Subject: RE: Y/105/19/PL and Y/106/19/L

Following our telephone conversation in April and previous email correspondence regarding the planning and listed building application for Stakers Farm Barns, we are intending to make the following amendments to the application to secure a positive determination:

Drawing Title
Proposed Plans - Barn 1

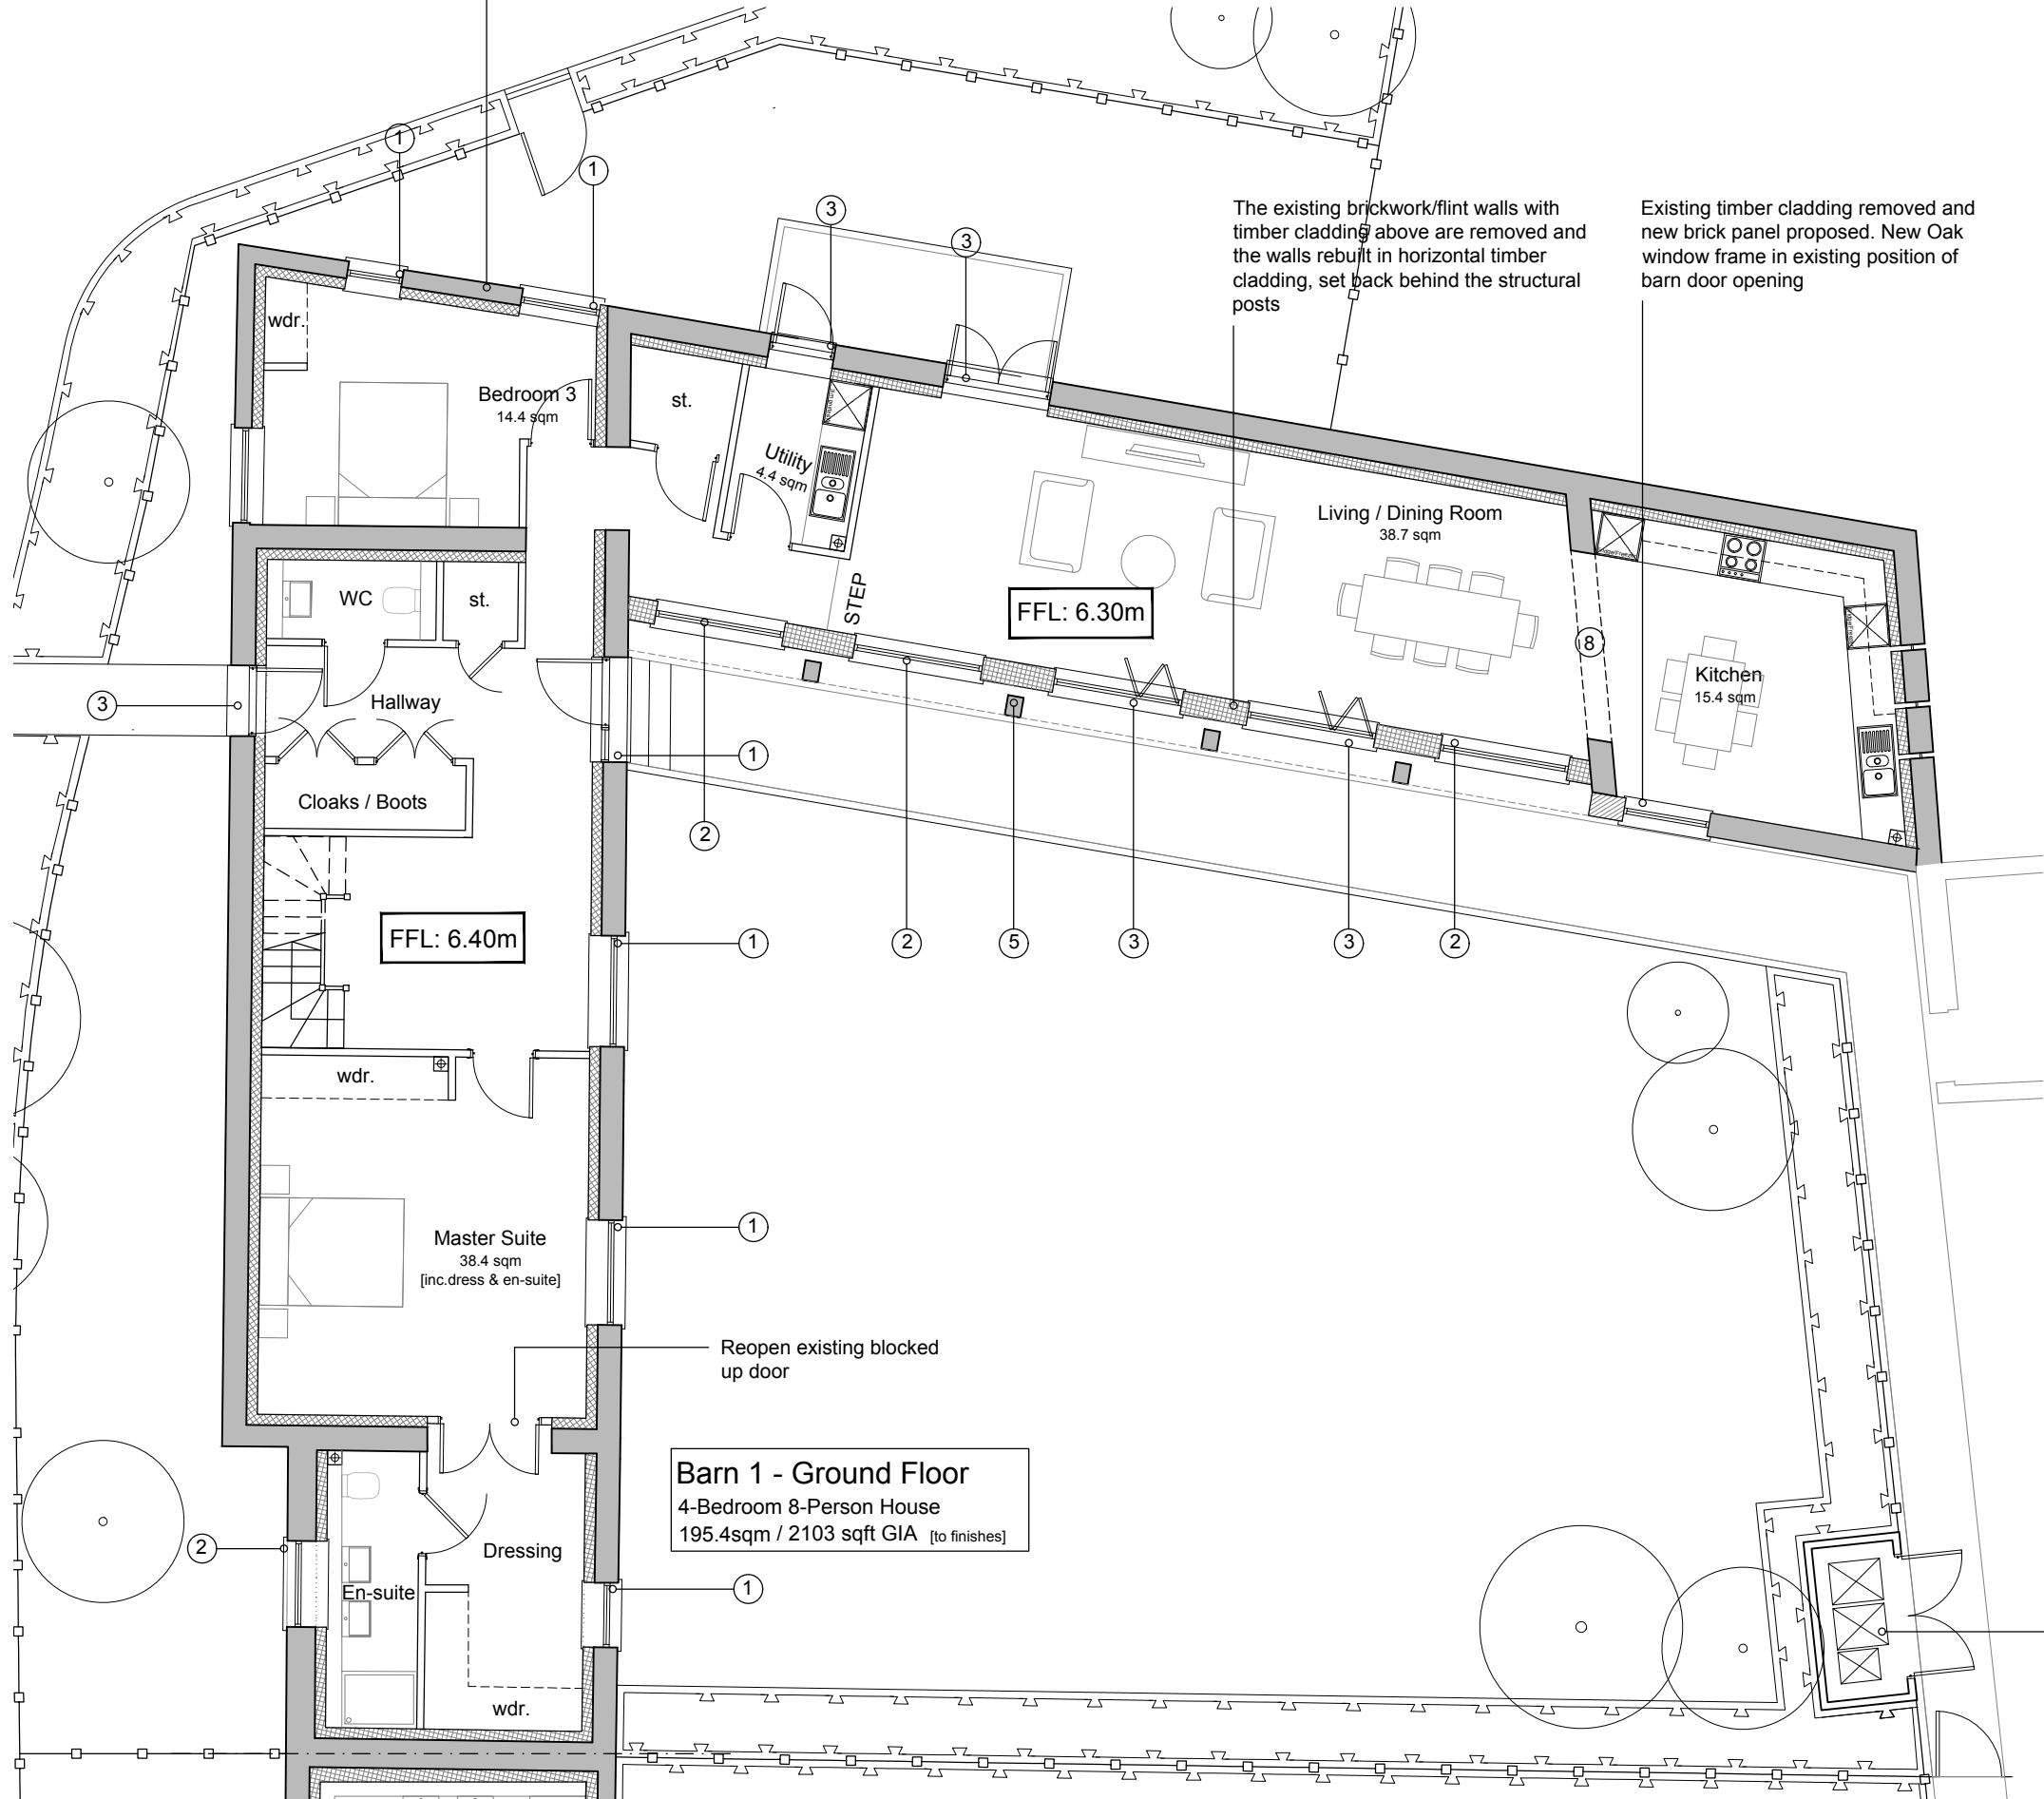
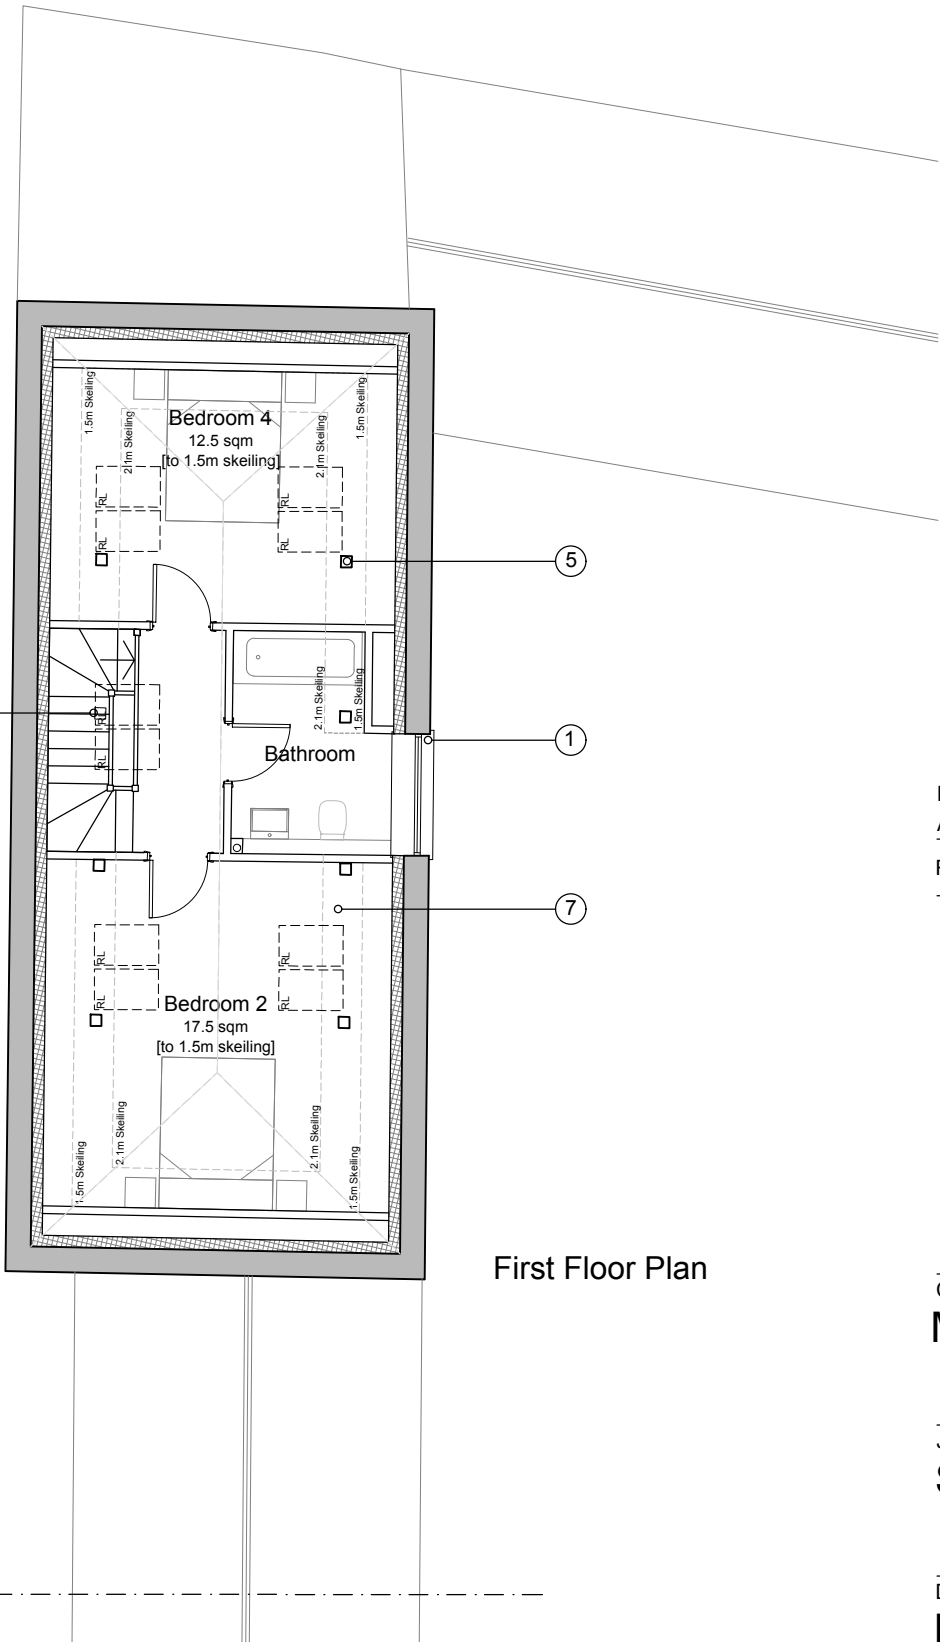
We will remove as many rooflights as possible from this barn. However, we cannot remove all the rooflights as we will need to provide light to the bedroom to make it a habitable space. A roof light will also be required to provide purge ventilation (Part F of Building Regs) otherwise a mechanical system would be needed. Under the Building Regulations we will also need to meet the Daylight and room brightness guidance set within British Standard BS 8206-2:2008 Lighting for Buildings. We will therefore seek to provide the very minimum amount of rooflights necessary to meet Building Regulations and seek to locate them on the least prominent part of the roof.

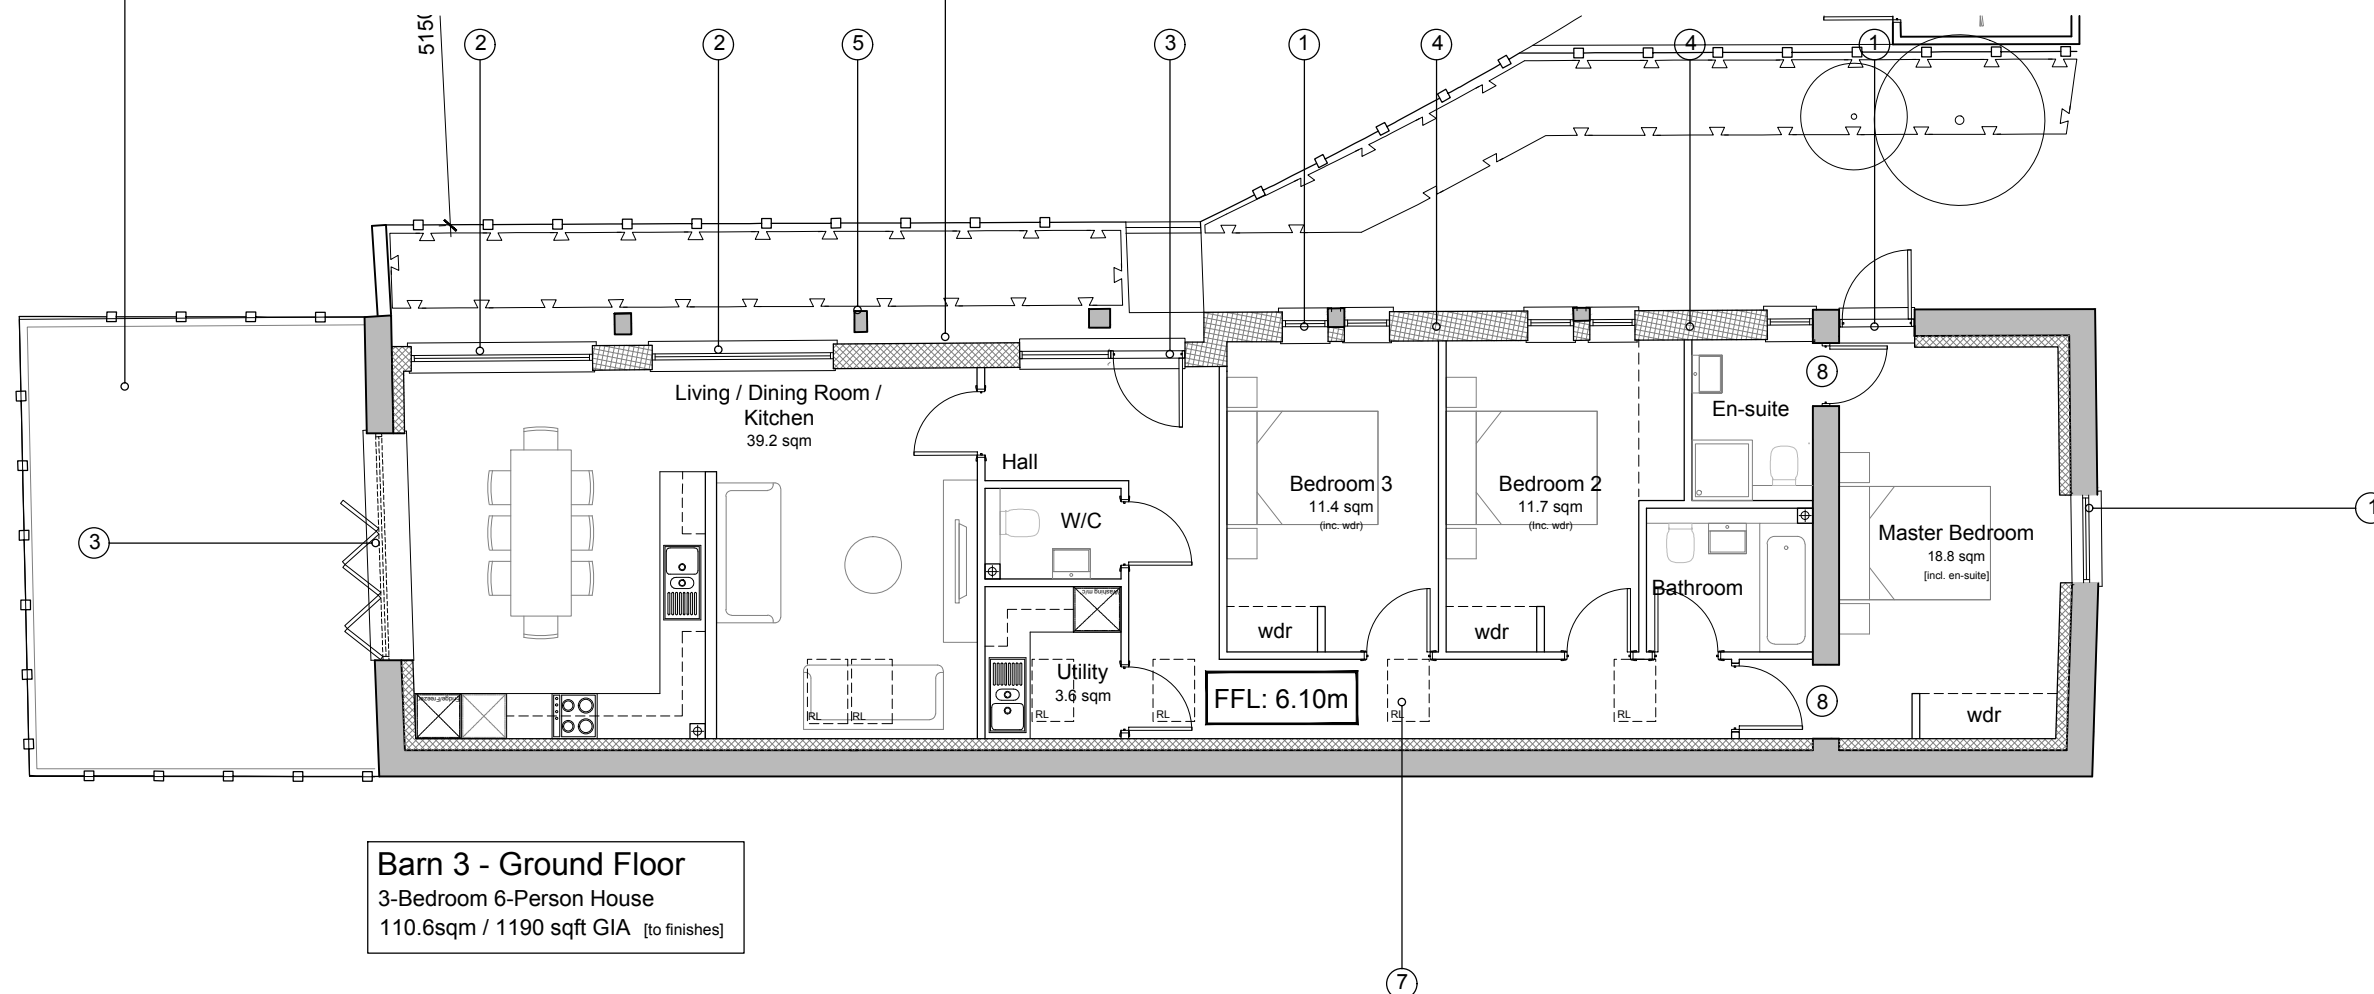
Amendments to the site layout so that the courtyard area to the east of barns 1 and 2 is used for car parking rather than used as garden space.

Drawing Title
Northern Boundary Section
Scale
1:100 @ A3

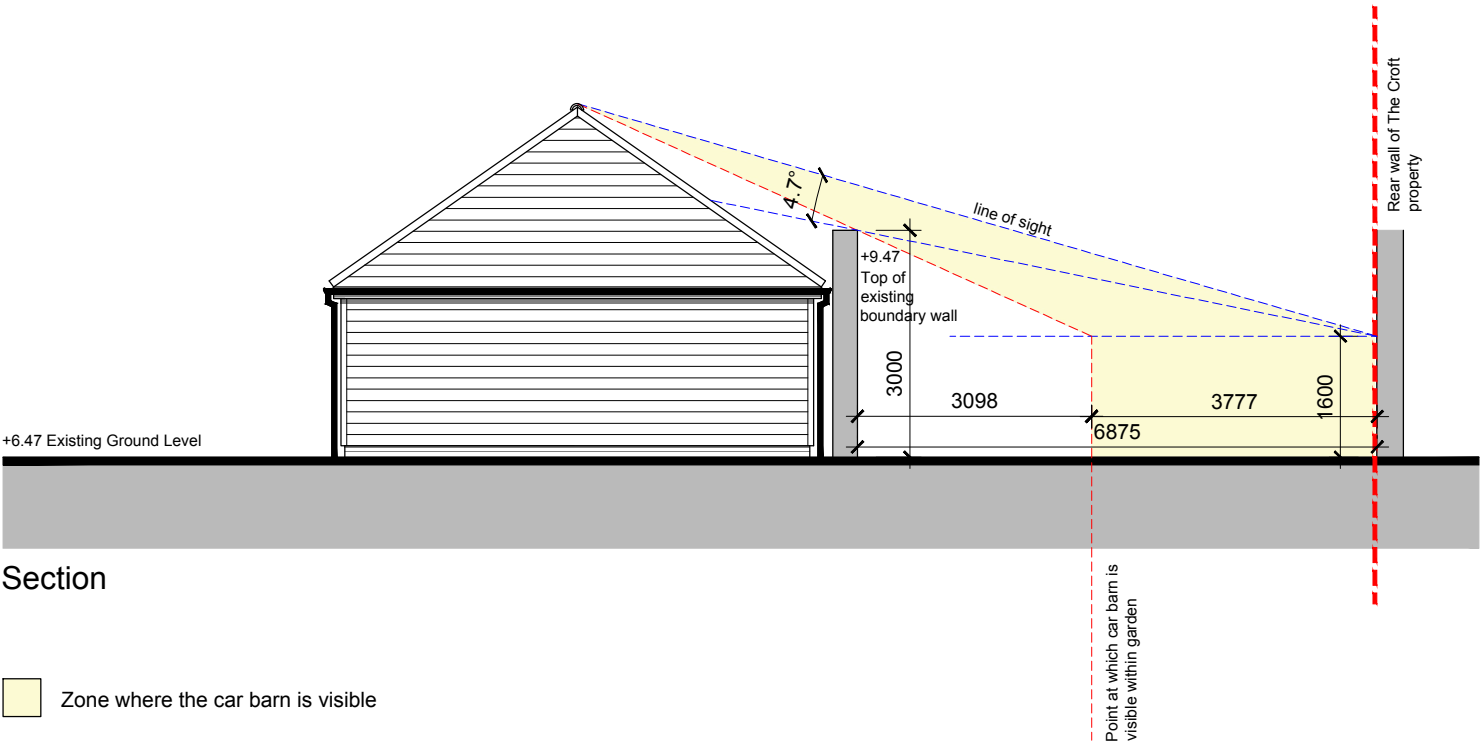
Deletion of the proposed car barns at the north of the site and the vehicular access to these barns, and provision of amenity space for barns 1 and 2 to the rear (west).
